Application No: AB/52/21/PL

Site Address: Old Bank House 3 High Street Arundel BN18 9AD

Description of works: Replacement of all windows with new timber double glazed sliding box sash windows and the proposed rendering of the South Elevation (front) with render painted white. This application affects the setting of a Listed Building and the character and appearance of the Arundel Conservation area.

No.1 No.3
PROPOSED SOUTH ELEVATION (1:100)

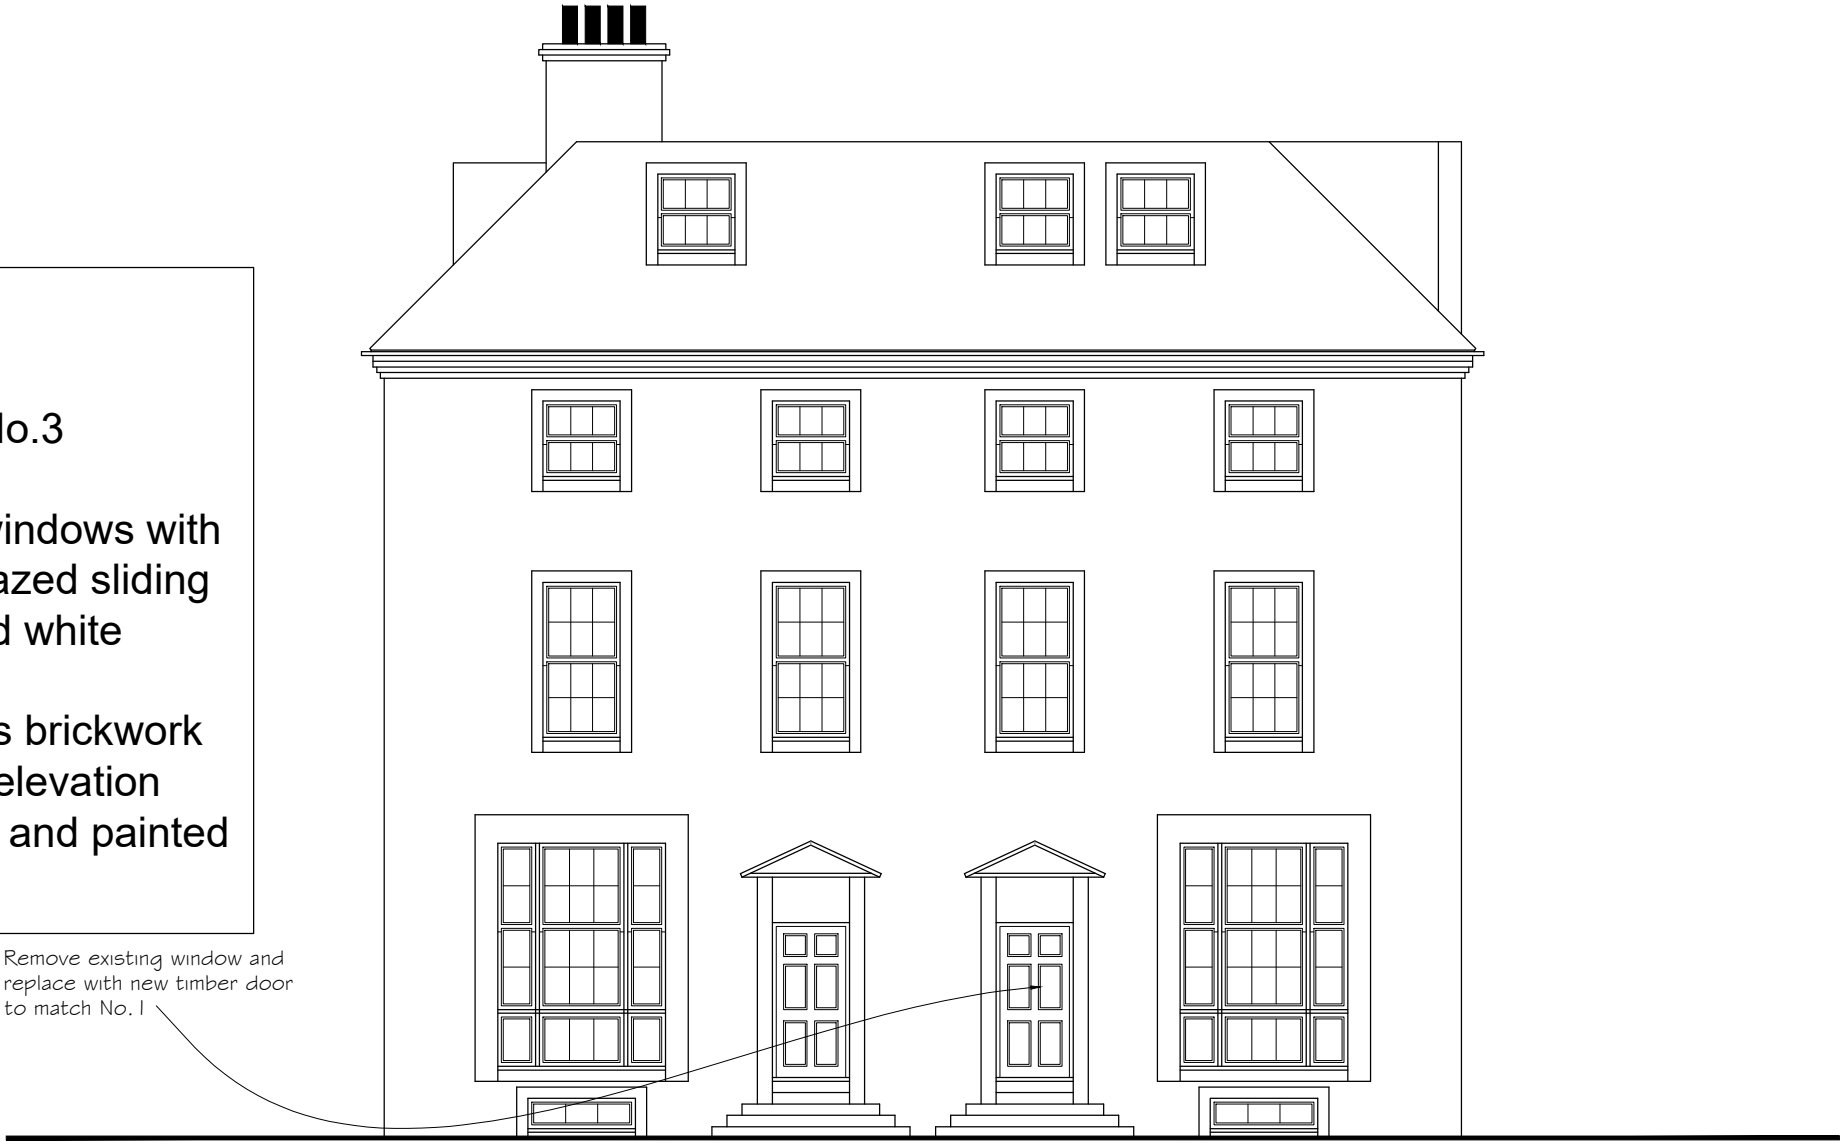
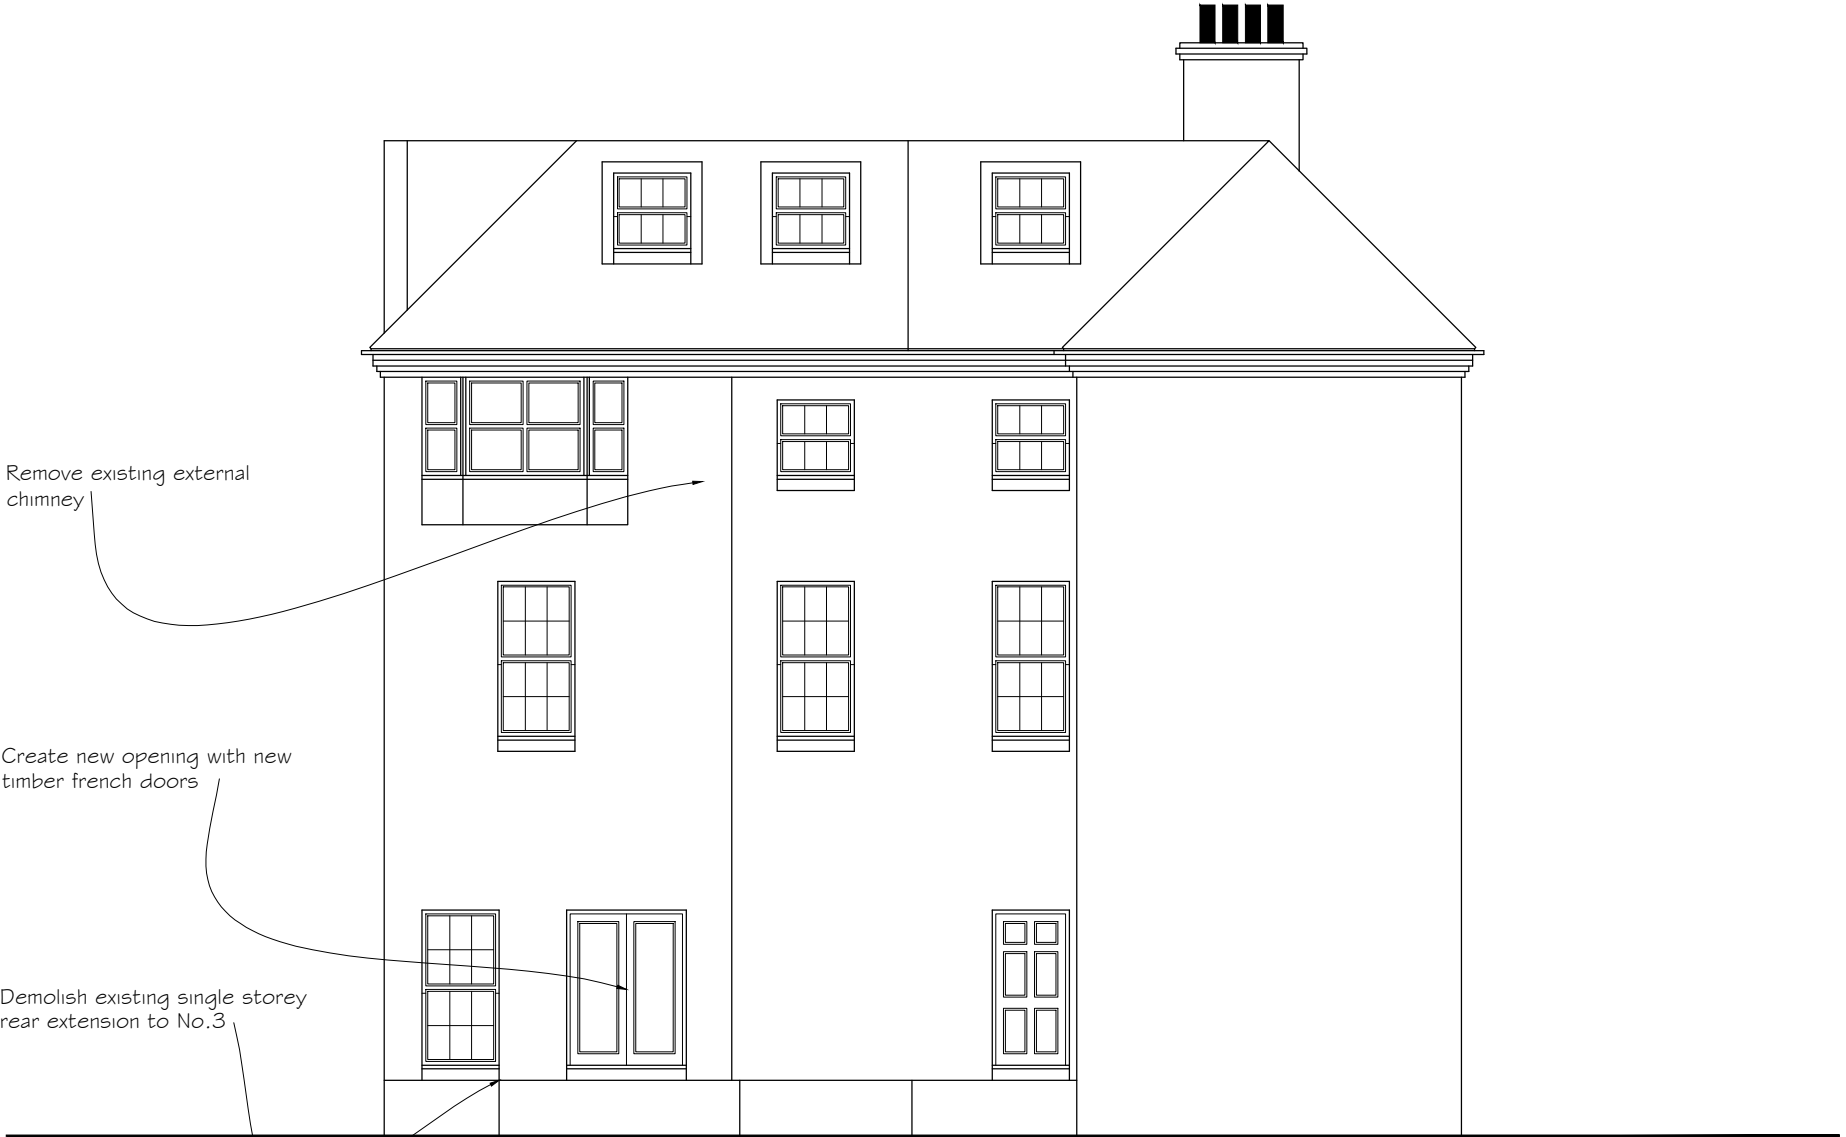
The replacement of this important fenestration with modern timber double glazed windows with their thicker glazing units, dead flat appearance to the glass and thermal spacers will materially detract from the historical and architectural significance of the building. It is difficult to ascertain from the submitted plans how any glazing bars will be treated. It is either intended to use false 'stick on' bars or to use properly formed bars but these would need to be thicker than the originals in order to take the extra weight of the double glazing (this would also likely be the case even with slimline double glazed panes). Either detail is simply not appropriate since the existing traditionally constructed and properly formed slender glazing bars are so important to the character and appearance of the historic building.

Without detailed proposed full elevational plans of the various window sizes contained in the building it is

difficult from the plans submitted to ascertain final appearances.

In any event, the works of replacement with double glazed units are totally unacceptable and permission should be refused.

The proposed works will undoubtedly adversely affect the character and appearance of the building and also, consequently, that of the conservation area. In addition, there will be an adverse effect on the setting of the adjoining listed building and, therefore, also on its significance.
